ENG-PUDSP22001-R2-GEC.pdf Markup Summary

CHICAL RECOMMENDATIONS PREPARED
D JANUARY 3, 2022, JOB NO. 181988.
Revised May 20, 2022

WQ POND G
1"=20'

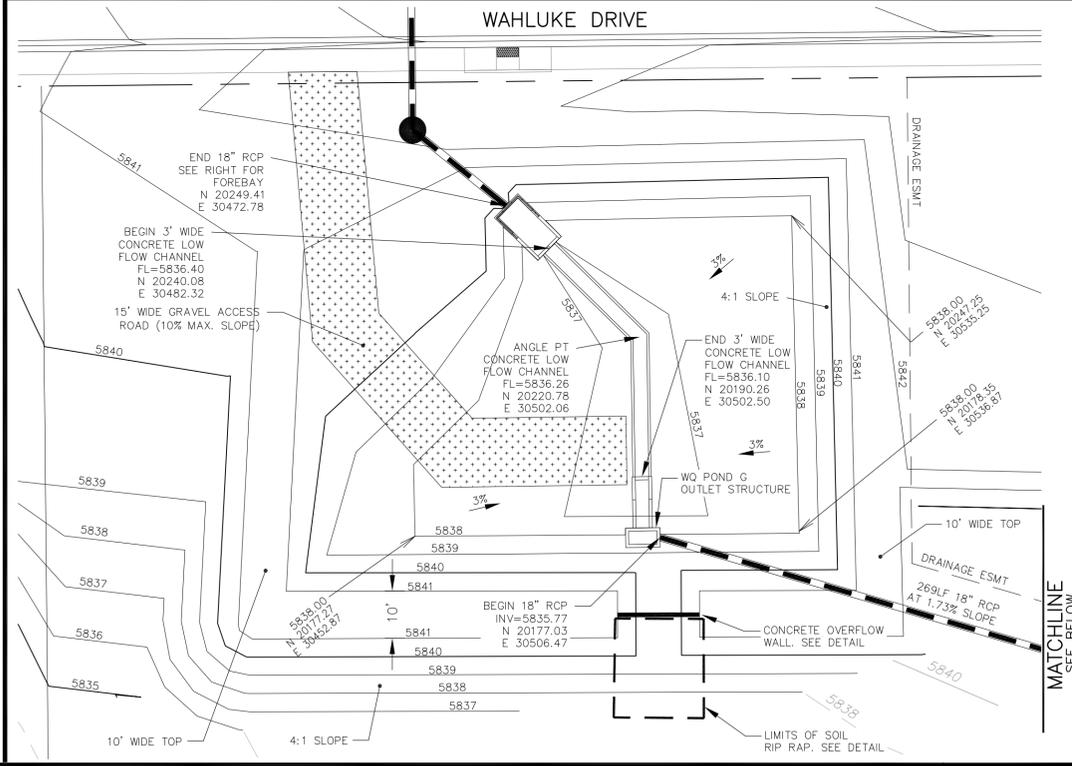
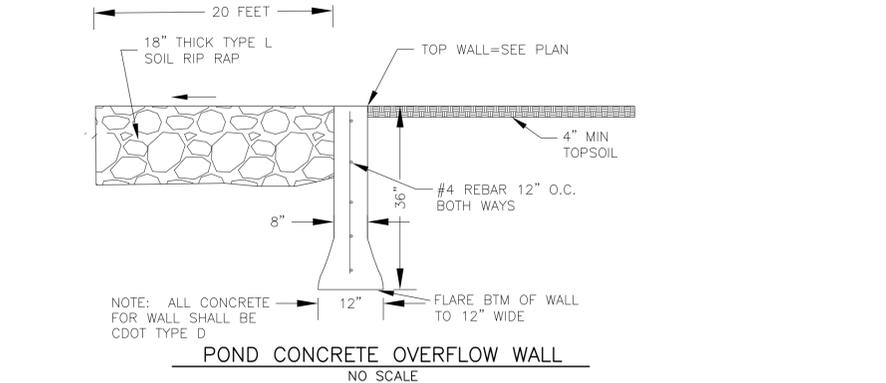
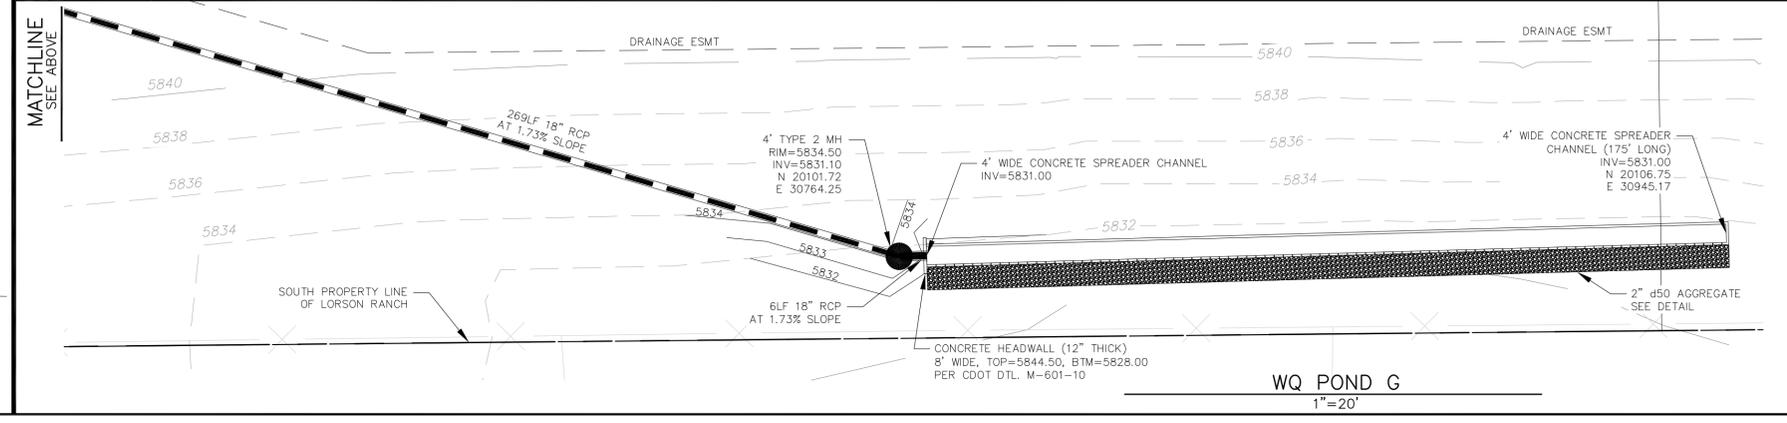
label emergency spillway

Unresolved comment from Review #1:
show emergency spillway and accompanying
details.

My thoughts:
I still don't think it's acceptable to not have a
spillway. MHFD criteria recommends directing
overflow through a spillway.

Rich's response:
there is no spillway since the pond was cut below
existing grade. the overflow is spread out over a
large area and will not erode the downstream
areas.
